**KIRKLEES METROPOLITAN COUNCIL
INVESTMENT & REGENERATION SERVICE**

**DELEGATED DECISION FOR DISCHARGE OF CONDITION AA.2(3) -
NOTIFICATION OF ENLARGEMENT OF A DWELLINGHOUSE BY
CONSTRUCTION OF ADDITIONAL STOREYS**

Reference no. 2025/CL/91906/W

**Site Address 35, Moor Park Avenue, Beaumont
Park, Huddersfield, HD4 7AL**

TITLE: FIRST FLOOR EXT'N & SINGLE STOREY REAR EXTENSION  
PROPOSED FLOOR PLANS & ELEVATIONS

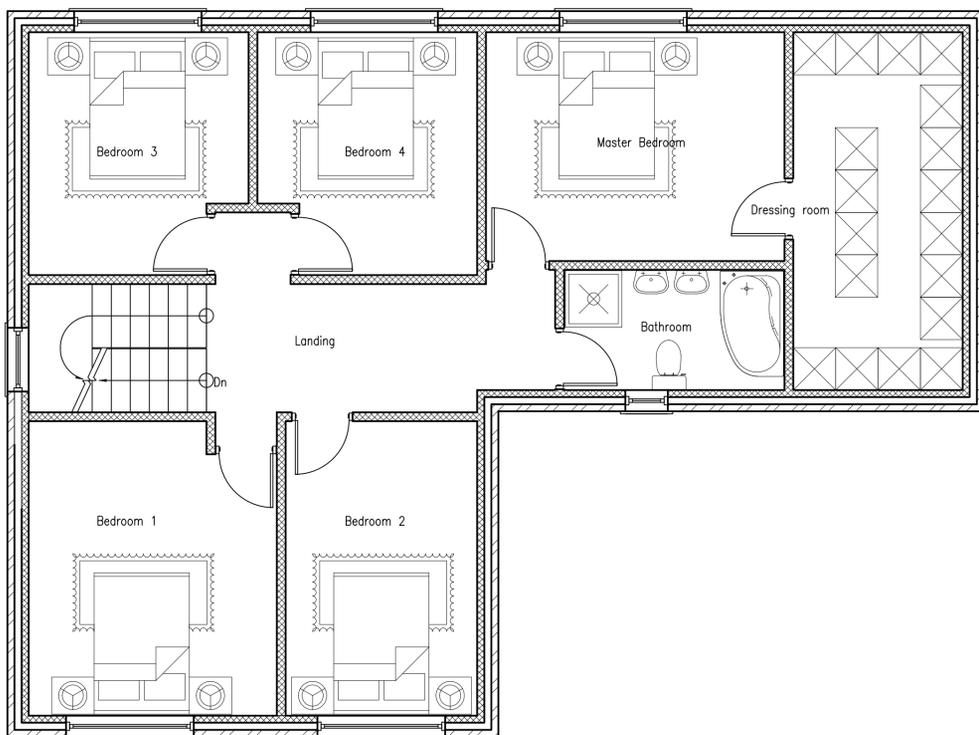
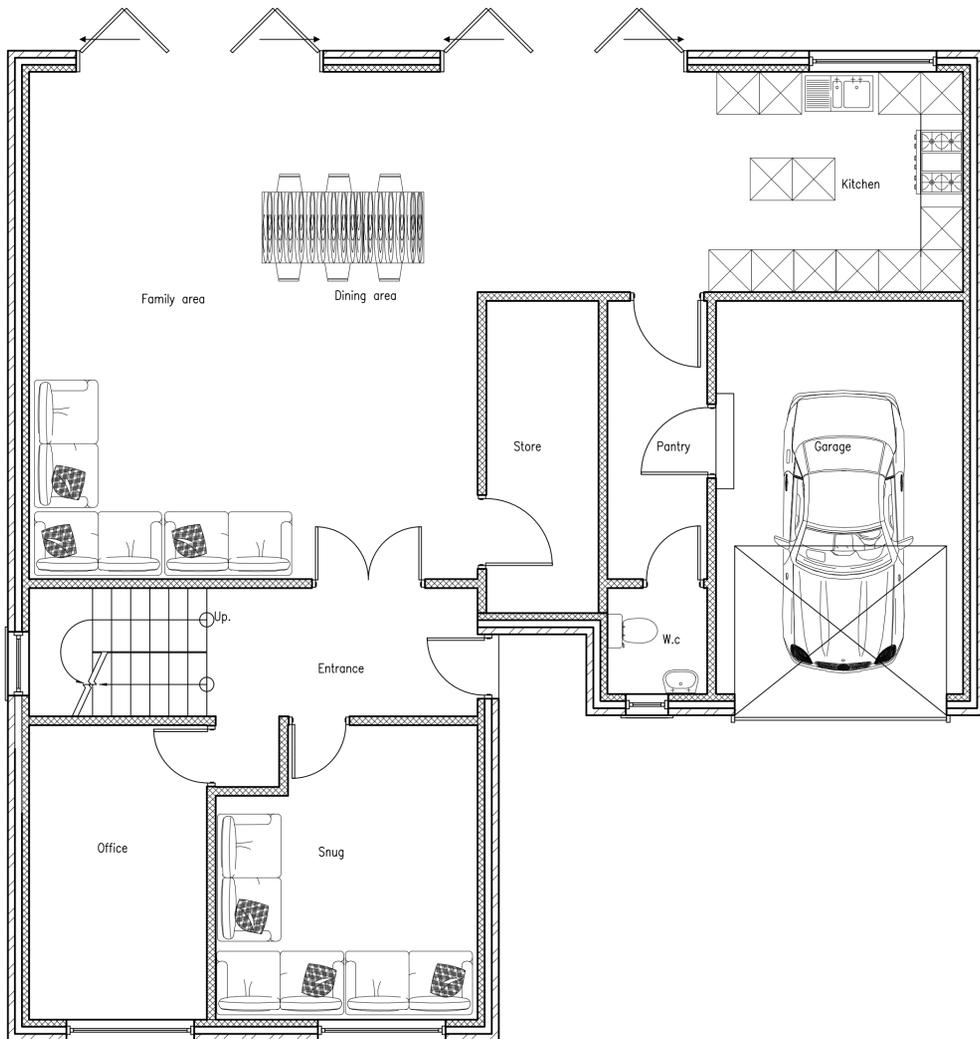
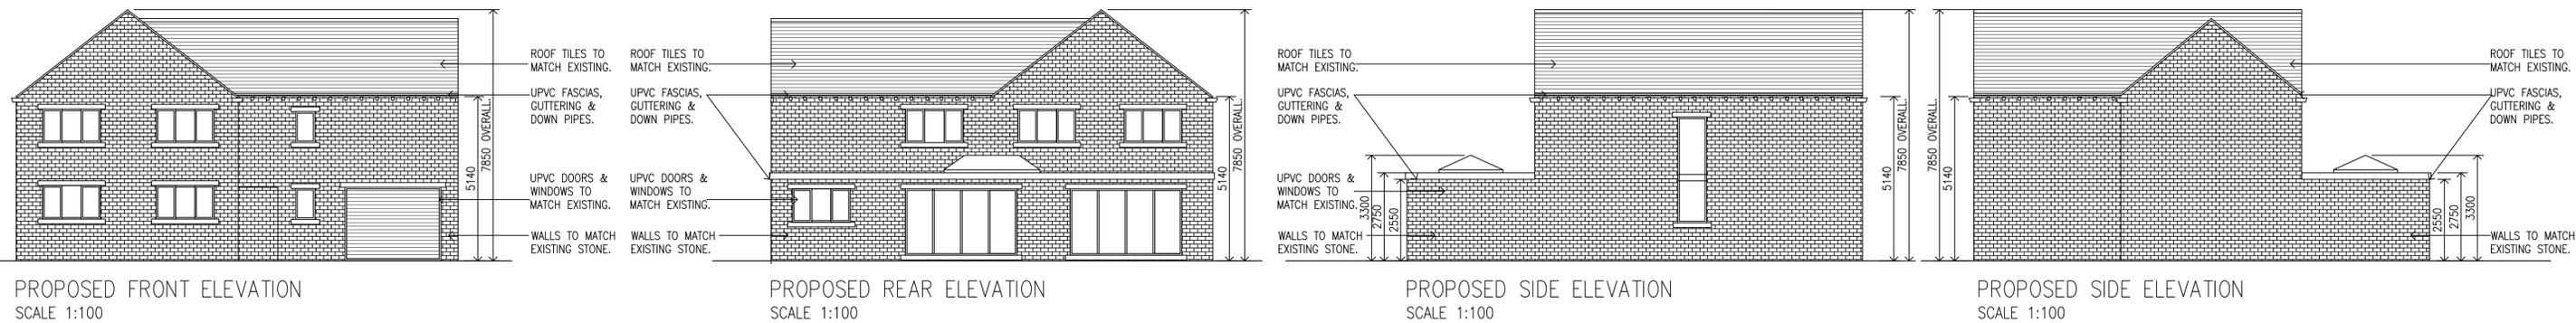
The applicant proposes an additional storey as well as a single storey rear extension to the existing building. The additional storey proposed would raise the height of the principal existing single storey main body of the dwellinghouse by 2.55m.

Openings within the ground floor would be reconfigured with addition and amended openings proposed, with the appearance of the additional storey being considered to match the existing property.

The proposed development will add substantial massing and bulk to the property and with regard to protecting amenity of adjacent properties, significant bulk will be added to the existing North, East, and South facing walls which are adjacent to neighbouring properties. Paragraph 135 of the NPPF and LP 24 (b) along with Key Design Principles 1-6 of the House Extensions and Alterations SPD seek to retain high standards for future and neighbouring properties including maintaining appropriate distances between buildings. Paragraph 4.3 and sub-paragraphs 4.7 to 4.15 place significant weight on protecting existing properties from losses of residential amenity. In this case and by virtue of the retention of separation distances and maintaining the orientation of all involved properties in the street scene, this additional bulk would not result in any significant loss of light into any windows or amenity space to neighbouring properties. Furthermore, as there are no additional habitable windows proposed in the North and South elevation of the first floor, and the windows proposed in the East facing elevation are considered to be an adequate distance from neighbouring dwellings it is considered that there will be no adverse impacts on neighbouring properties with regard to overlooking and privacy in this regard.

The additional bulk and massing will have a towering effect on neighbouring properties which would appear more imposing than current arrangements. However, there are sufficient separation distances between the site and surrounding properties so as not to cause undue harm from overshadowing.

The proposed additional storey to the existing bungalow will have the effect of substantially changing the character and appearance of the existing property. The introduction of a full additional storey creates additional bulk and presence to all elevations when viewed from public vantage points which surround the site to all elevations.

The proposed development in this instance is simplistic in so far as the proposal is to add a storey onto the main body of the bungalow. This results in a significant change to the existing lines and proportions of the building resulting in an increase in roof line and how the building would be viewed from public vantage points surrounding the site. When currently viewing the property, it is a bungalow which is also surrounded by bungalows to the North, South, and East. The site also contains a double single storey garage which appears as a balanced extension to the North of the original dwelling.

Considering the above assessment, the proposed additional storey would result in an overly dominant feature that would be out of character with the existing property and within the street scene where the dwellings are single storey, resulting in considerable disruption to the character of the building and rhythm of the street scene. The alterations to the proportions of the building would also result in an overly prominent structure which would be out of keeping with the host and surrounding properties, contrary to Key Design Principles 1 and 2 of the House Extensions and Alterations SPD and Policy LP24 of the Kirklees Local Plan.

It is therefore considered that the proposed additional storey would be overly dominant and harmful to the proportions, appearance and design of not only the principal east facing elevation but also the dwelling as a whole,

neighbouring properties and wider street scene. This would be contrary to the fundamental core aims of good design set out in Chapter 12 of the NPPF, Policy LP24 of the Kirklees Local Plan and Key Design Principles 1 and 2 of the House Extensions and Alterations SPD.
